Mill Cottage, Clymping Mill

Addendum to
Planning & Heritage Statements

Mill Cottage - Addendum to Planning & Heritage Statements in support of changes to previously approved applications CM/22/18/L and CM/6/19/HH

MILL COTTAGE: DOORS AND WINDOWS 1:25 @ A3

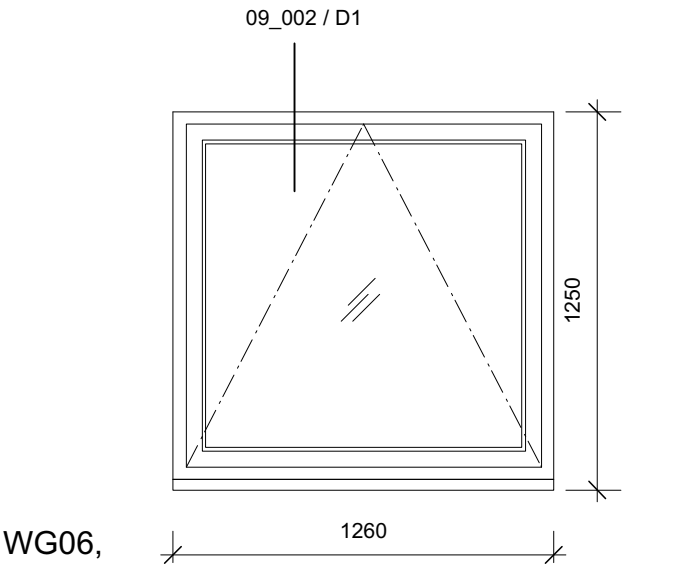
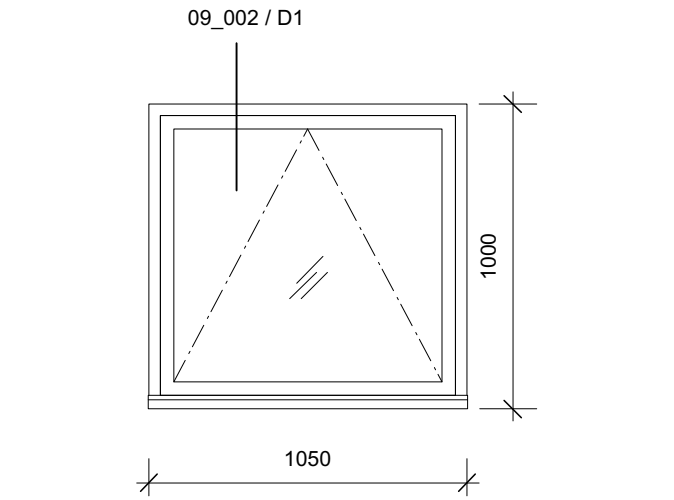
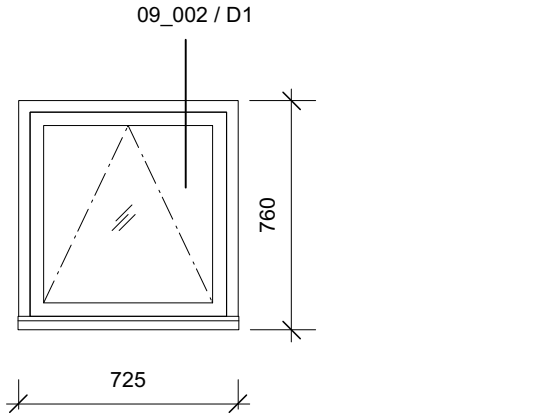
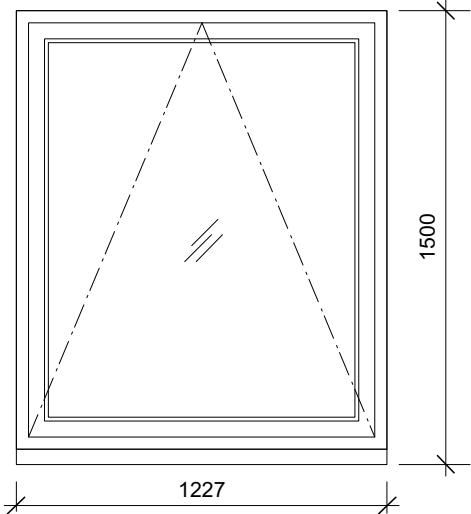
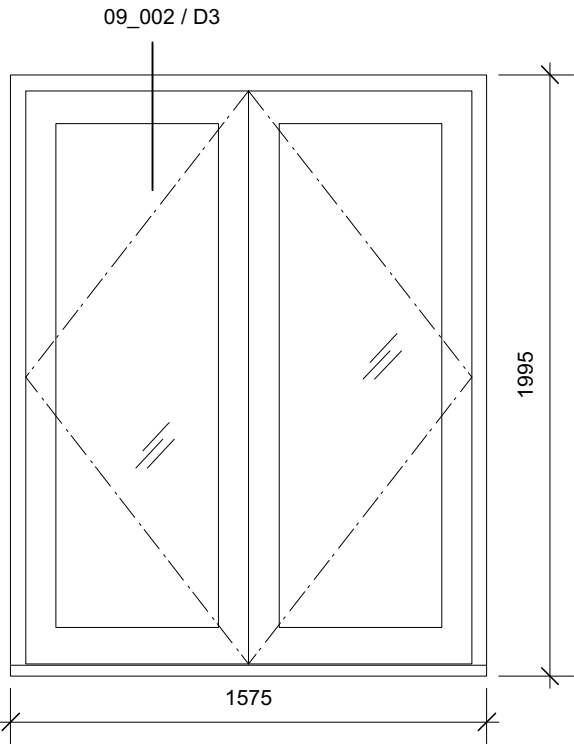
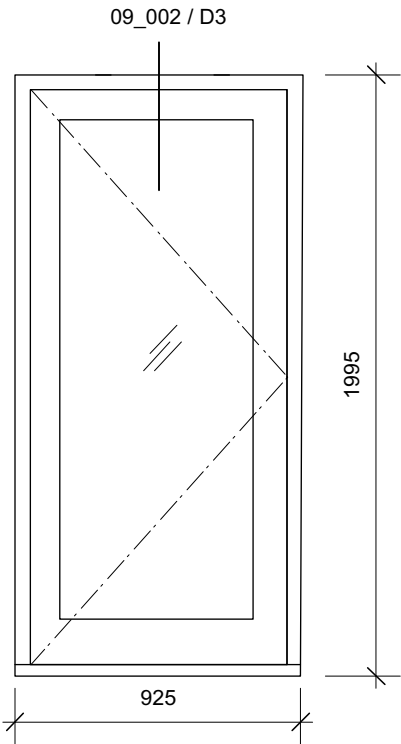
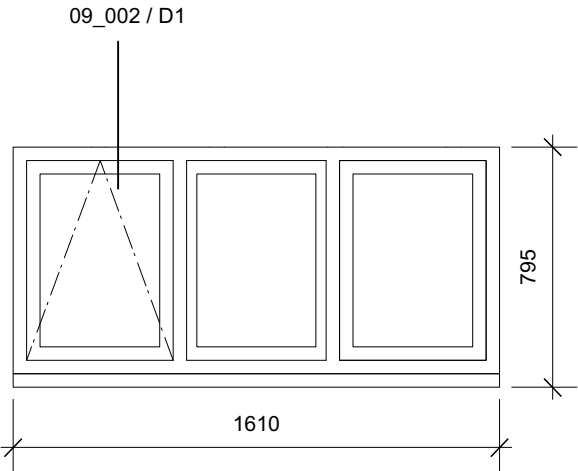
1) Window fenestration

This revised application proposes a simplified window fenestration which adopts a more utilitarian aesthetic, more in keeping with the former mill buildings. The horizontal bar is removed and the double glazed units are 24mm to provide better thermal insulation and protection from climate and theft. The revised windows are an enhancement to the current UPVC windows, and with little or no evidence of previous window treatments we think it appropriate that the aesthetic is a simple, contemporary interpretation of the utilitarian nature of the original mill buildings – see appendix plate 4

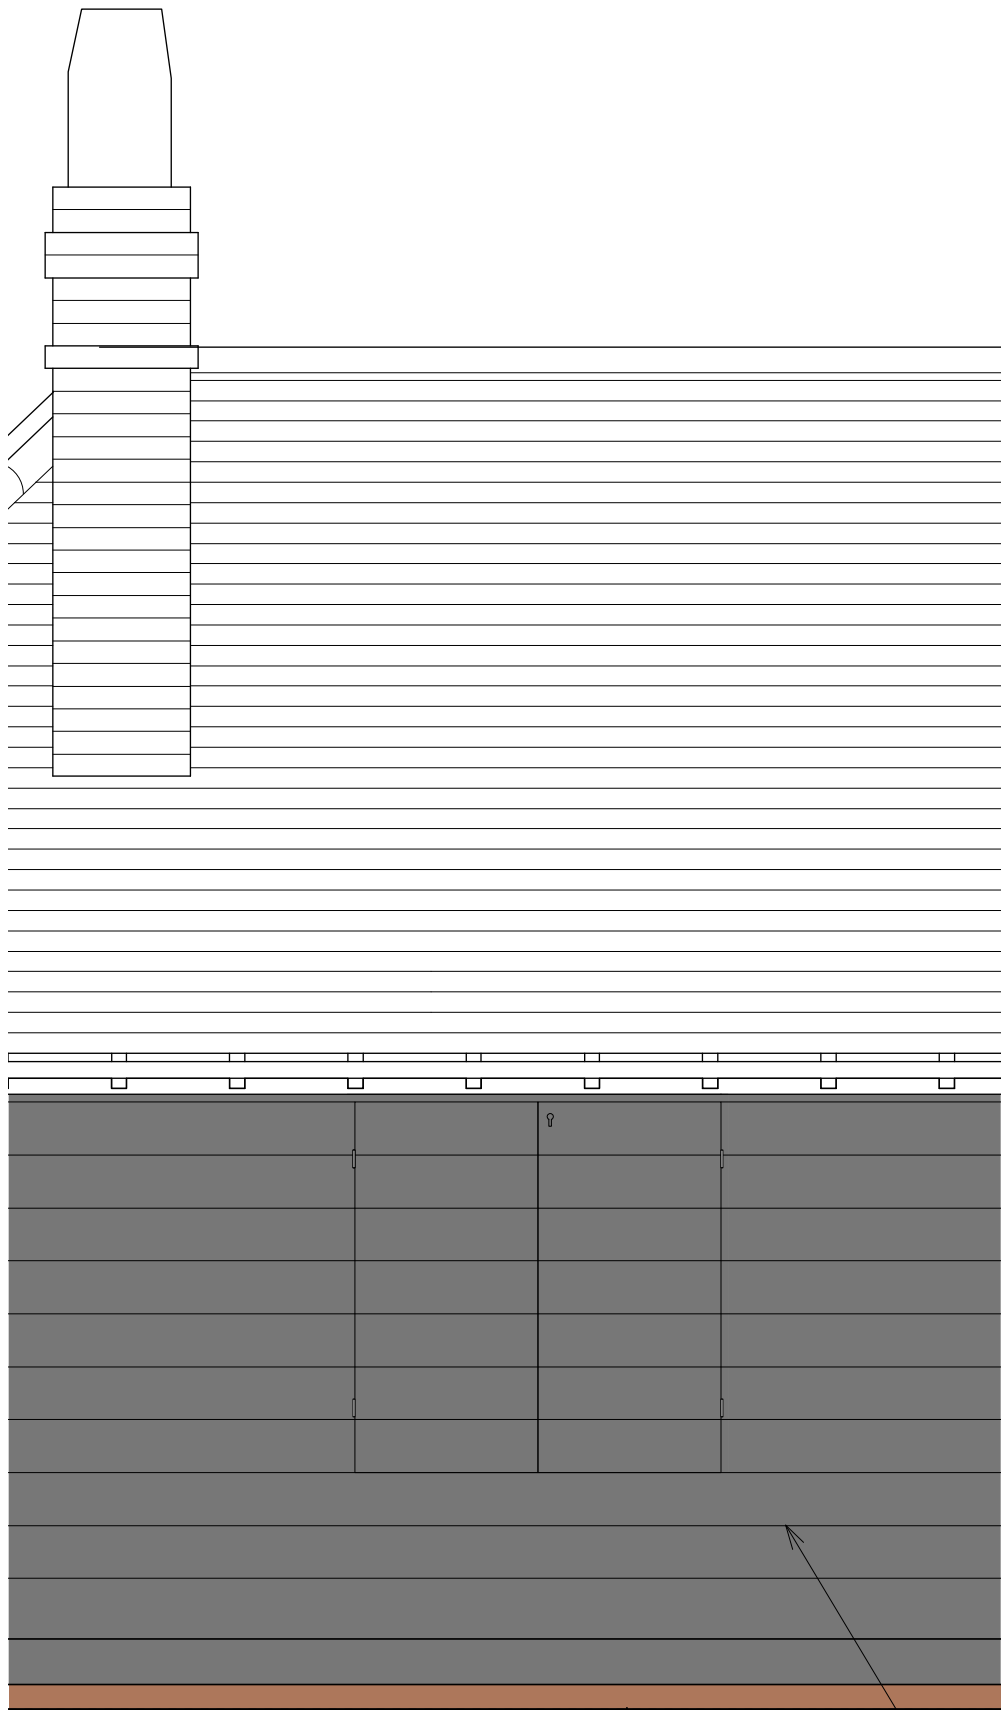
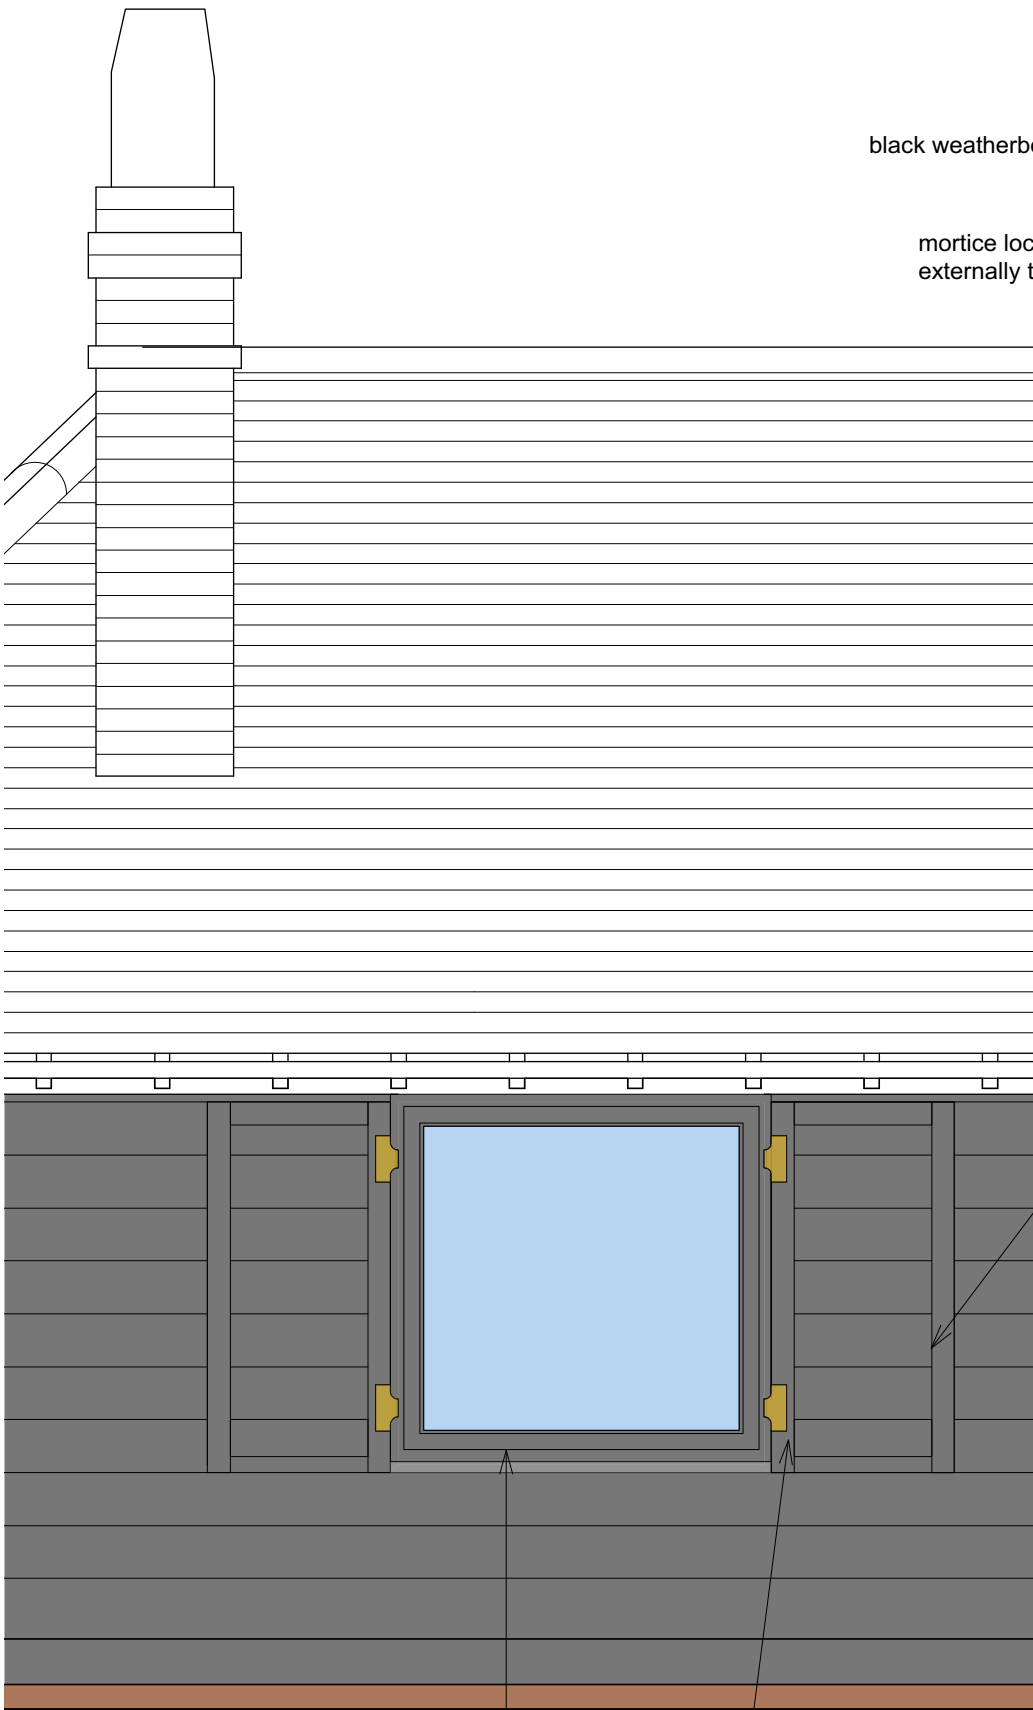
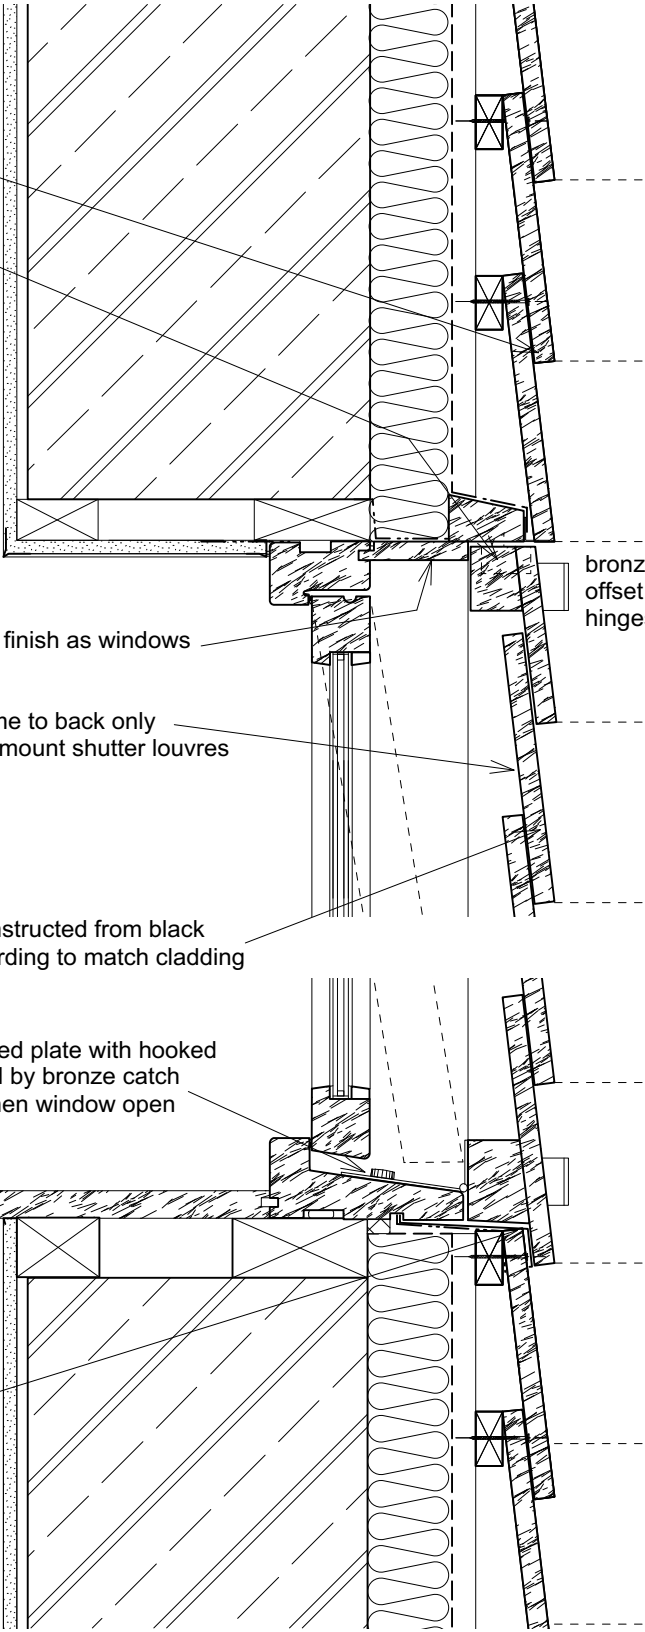
2) Shutters

The proposals show shutters added to all glazed windows and doors to provide much better security and climatic protection. Historic photos indicate shutters have been used on a number of the doors and windows in the Mill Cottage and Thatch Cottage, both when used as barns and then later in their conversion to residential use – see appendix plates 5a & 5b.

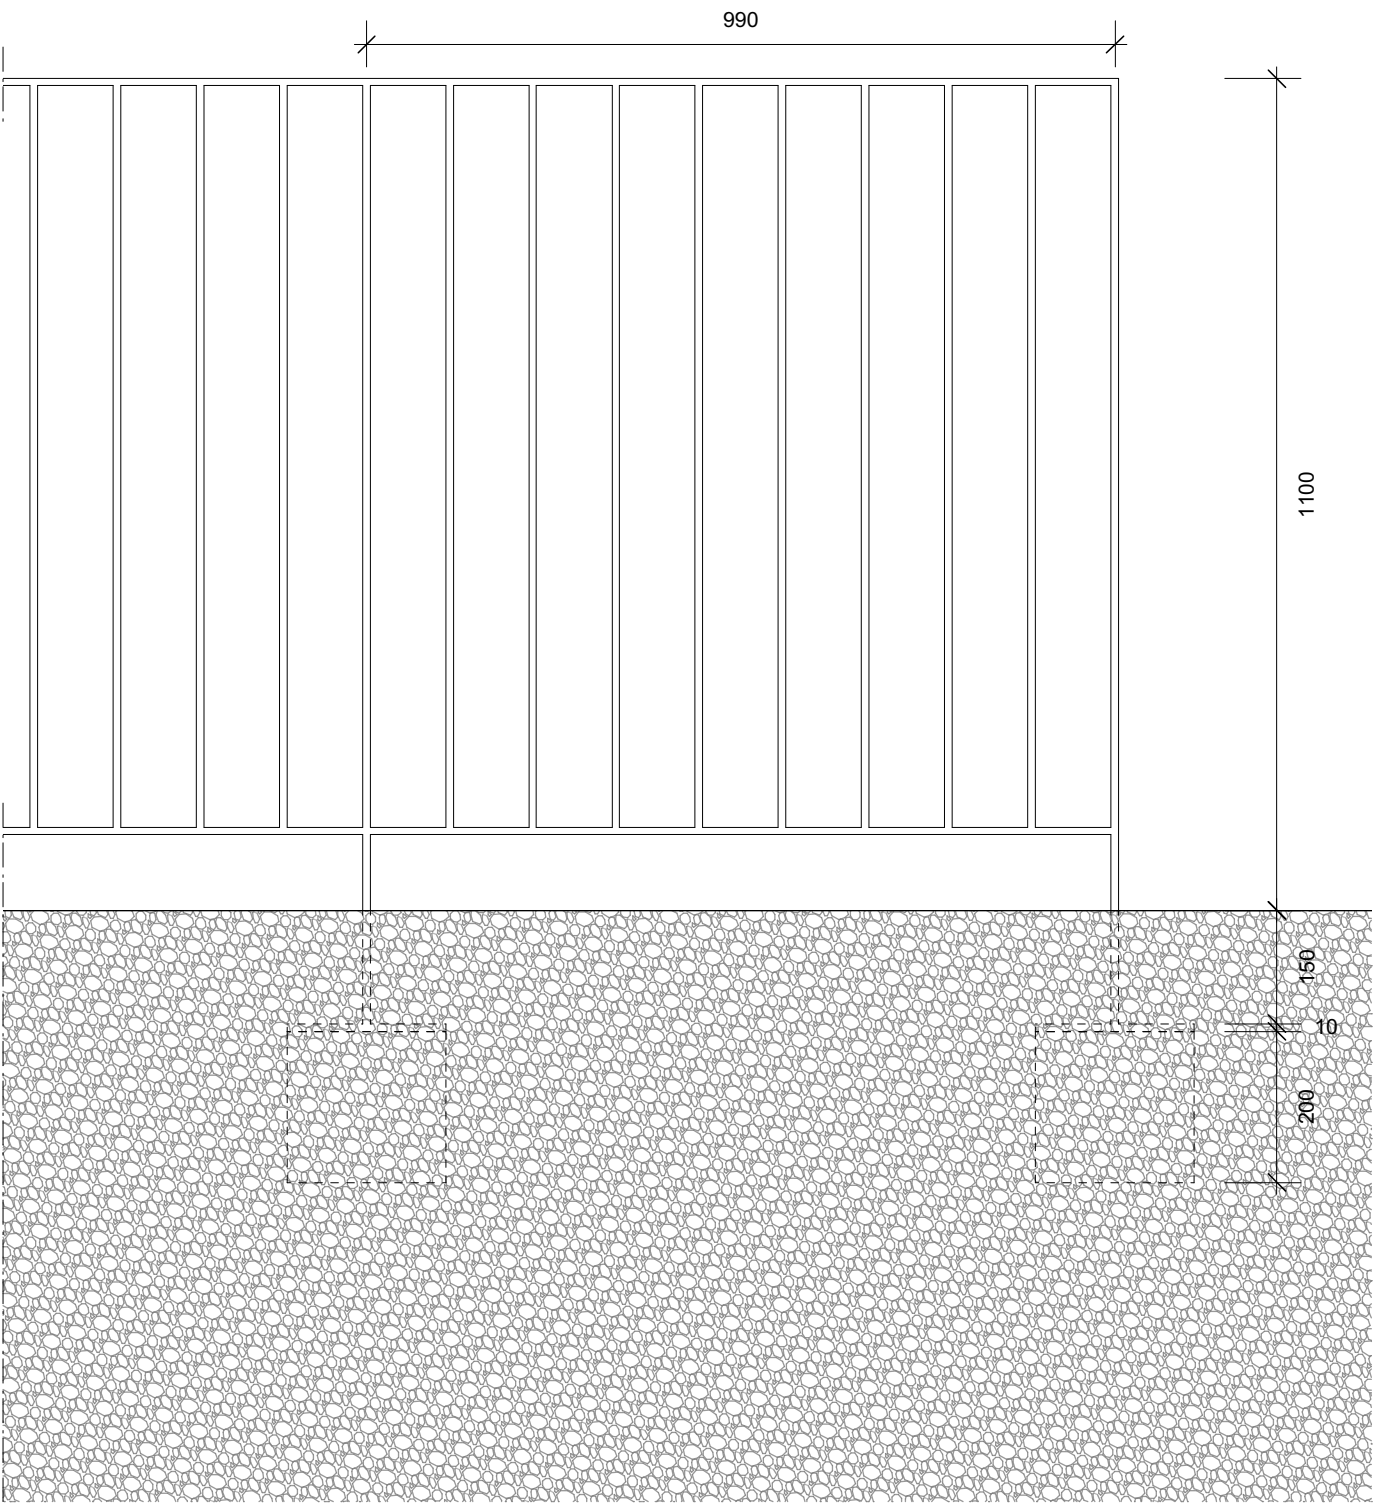
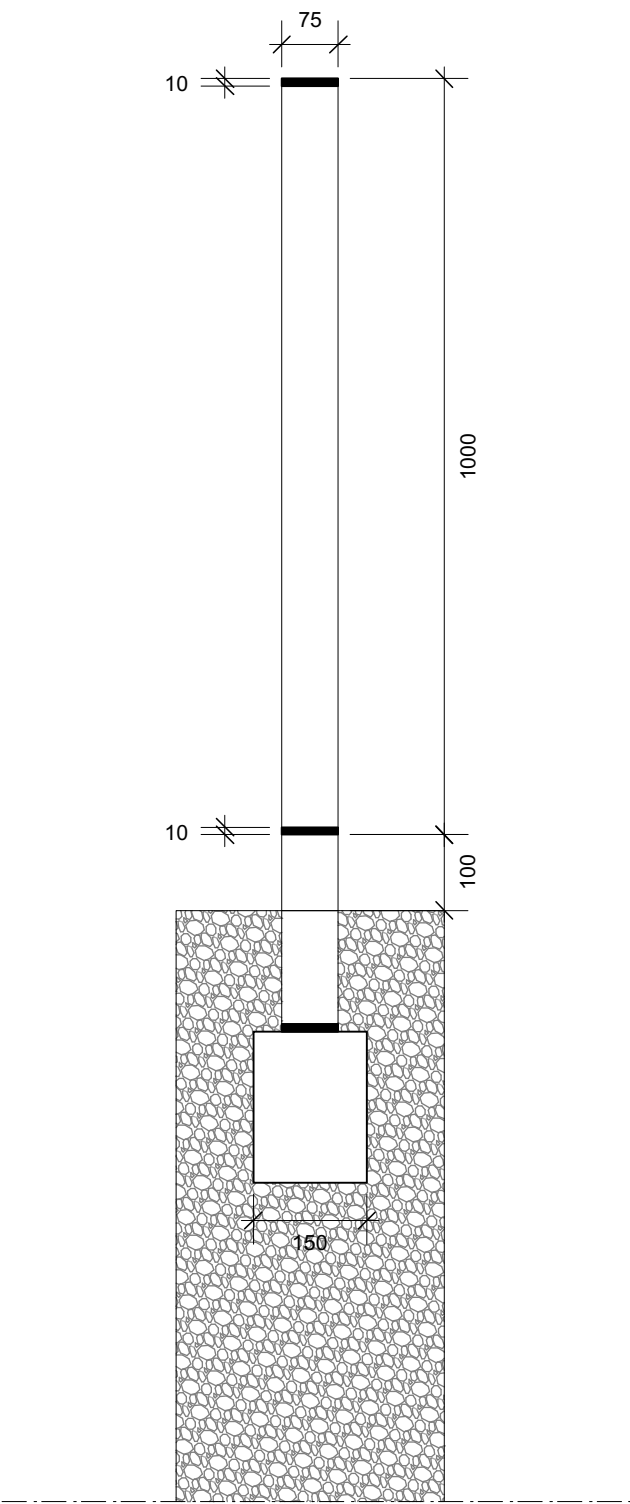
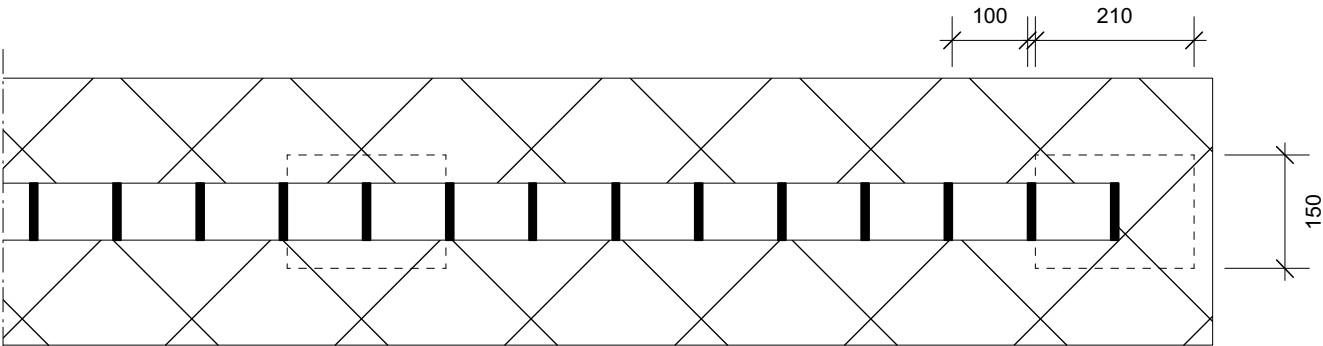
6) Balustrade

Details provided as stipulated as a condition of previously approved applications.
